Application No: BN/122/24/HH

Site Address: 43 Elm Grove Barnham PO22 0HL

Description of works: Erection of front link attached garage and workshop with home office above.

FOR MR S. DOWNES		
SITE 43 ELM GROVE, BARNHAM, WEST SUSSEX. PO22 0HL		
TITLE PROPOSED GARAGE/ WORKSHOP ELEVATIONS		
SCALE 1:100	DRAWN AH 08/24	DRAWING NO. 04 REV

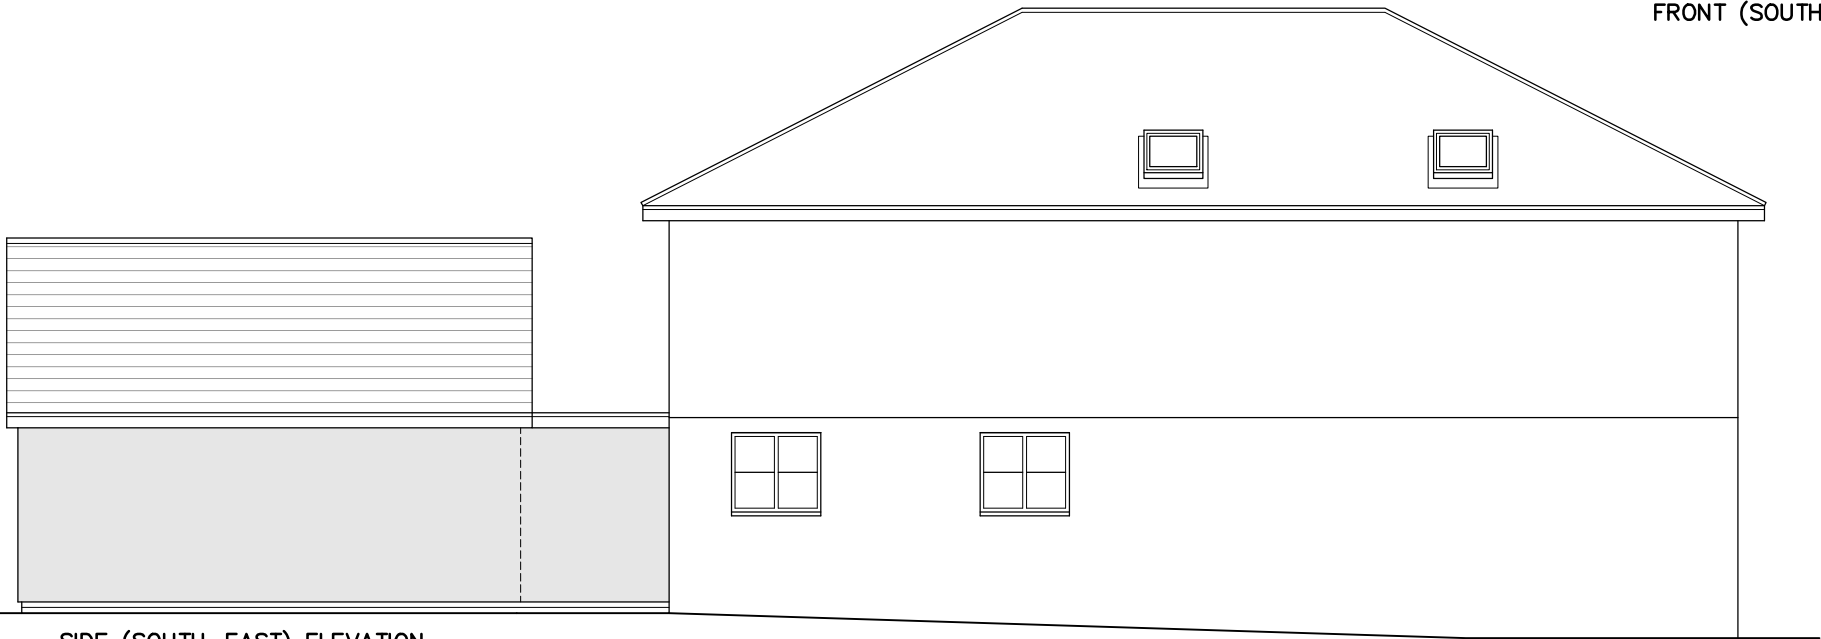
Objection to proposed garage workshop linked extension, on grounds of scale, and breach of covenant. Having previously added a 6 metre 2 storey extension to the North side of the house in 2021, adding a further 6.5 metre garage and workshop, plus a 2.015 metre link on the South side will result in a 22.7 metre long continuous building, which is excessive on a domestic plot.

FOR MR S. DOWNES		
SITE 43 ELM GROVE, BARNHAM, WEST SUSSEX. PO22 0HL		
TITLE PROPOSED GARAGE/ WORKSHOP FLOOR PLANS		
SCALE 1:100	DRAWN AH 08/24	DRAWING NO. 02 REV A

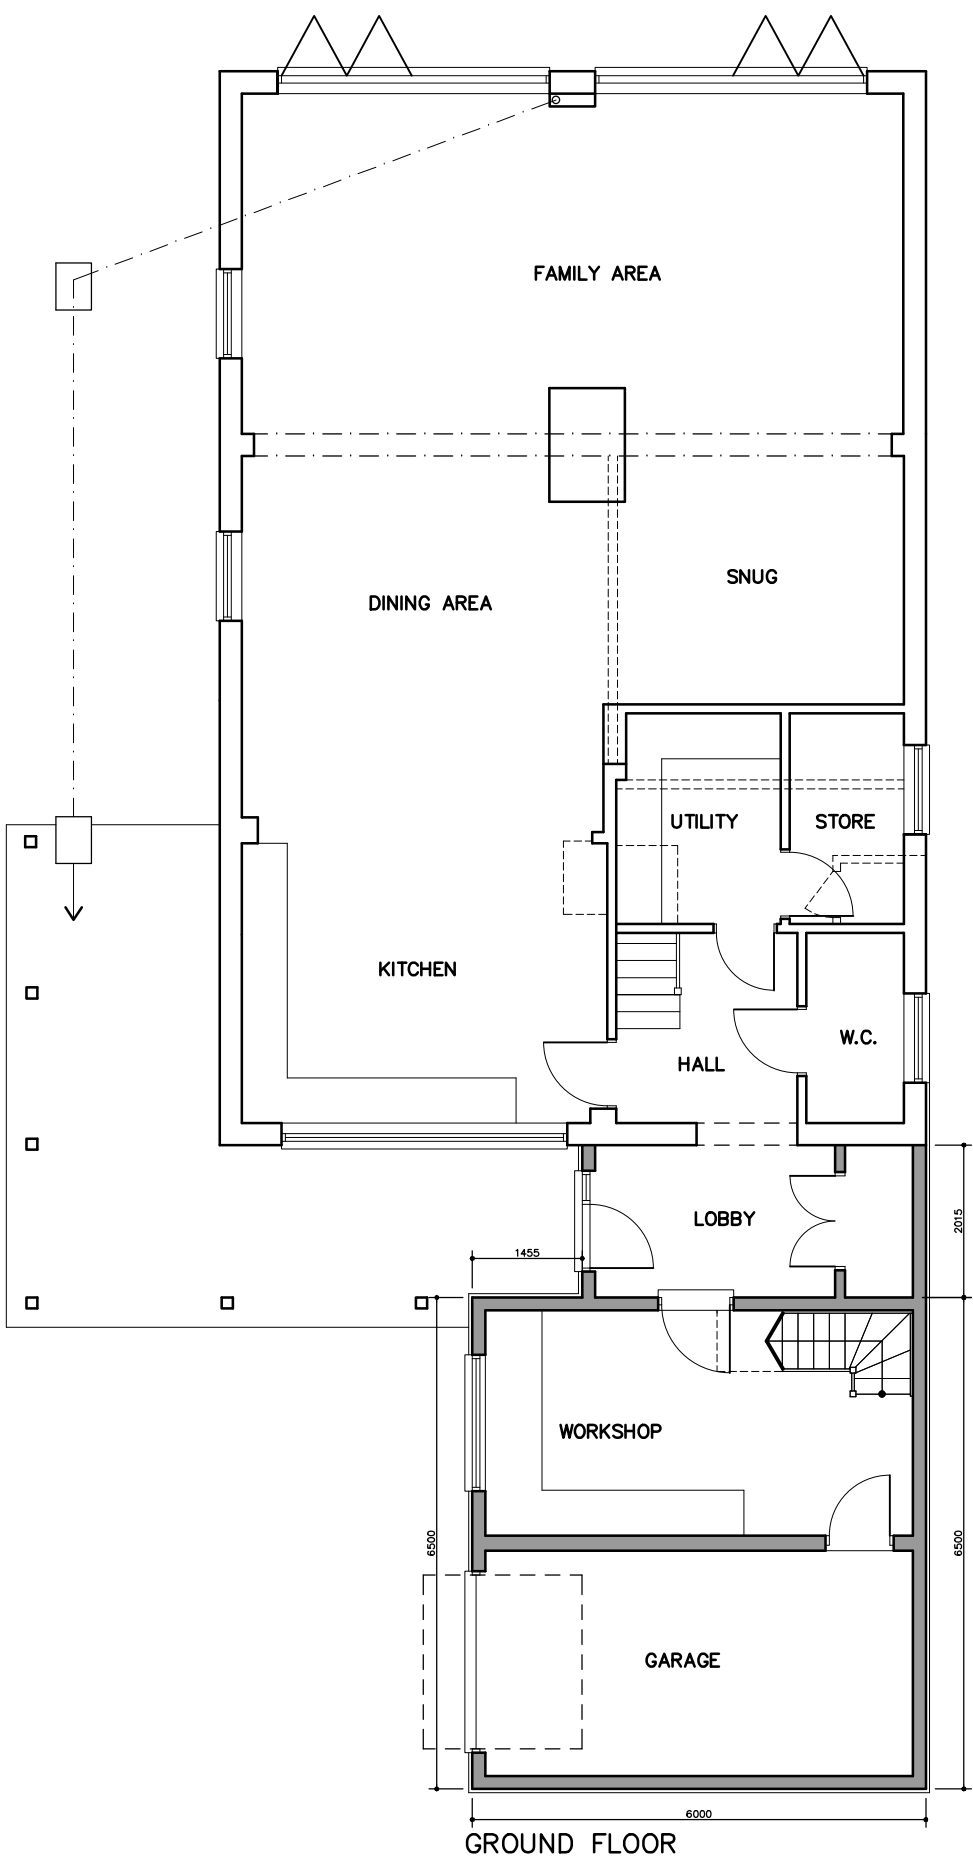
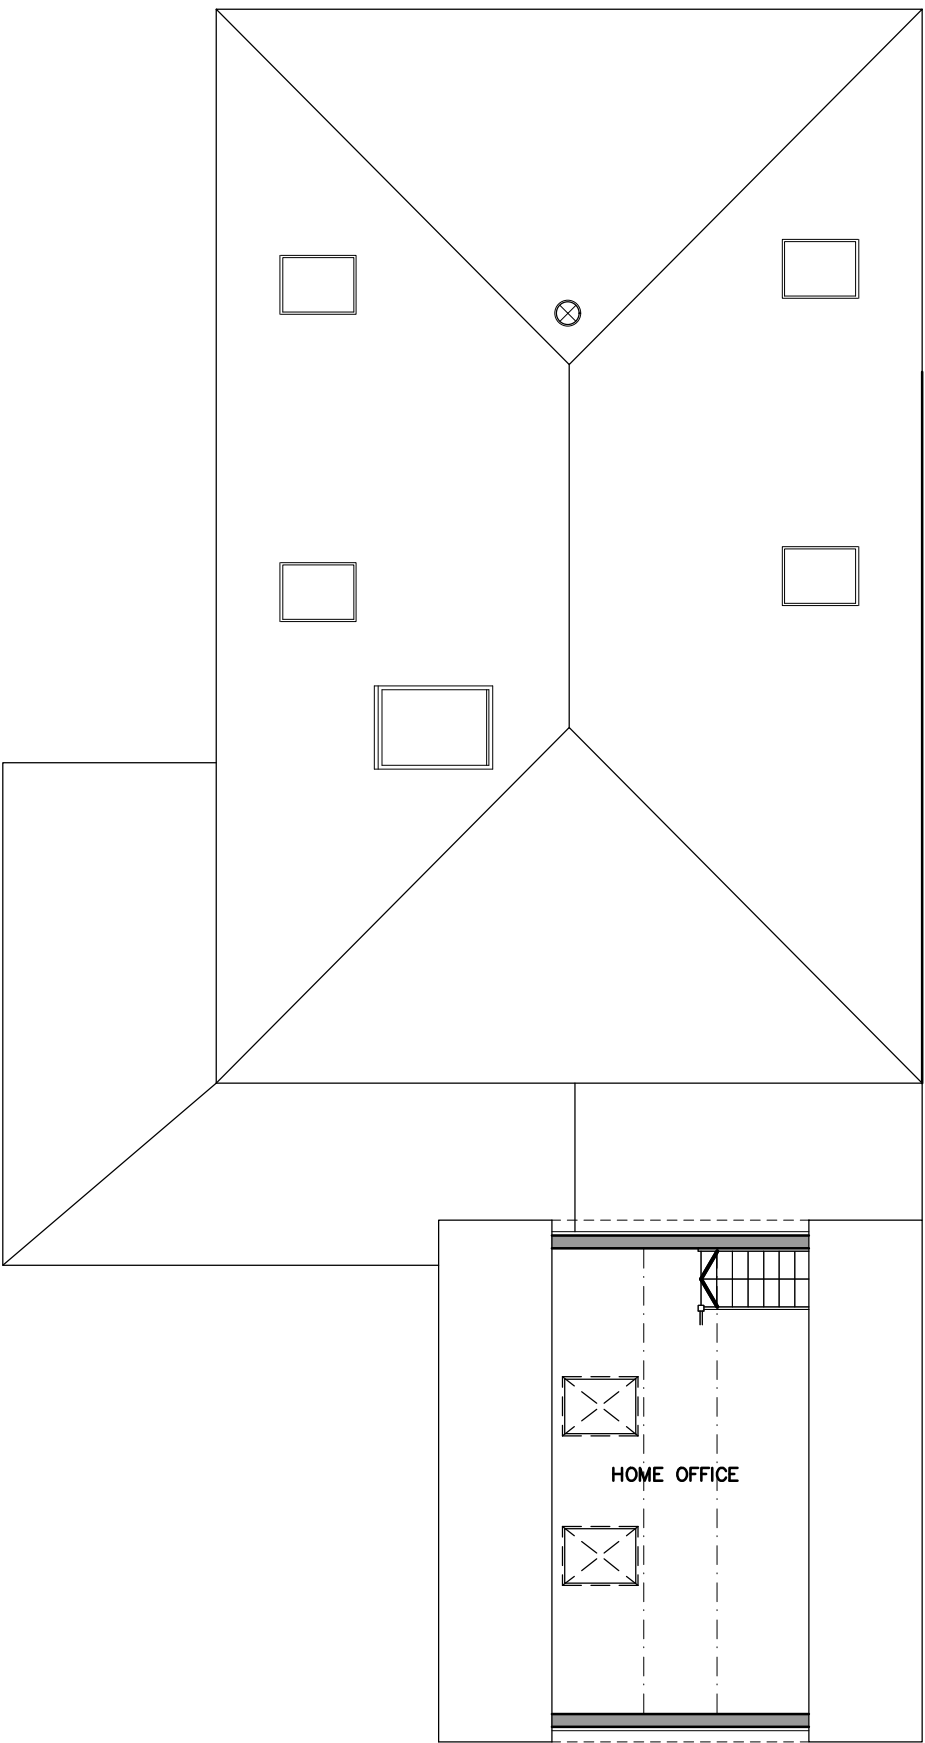
The proposed garage shows a distance of 8.1 metres to the front boundary, which is within the 9.1 metres (converted) stipulated in the covenant.
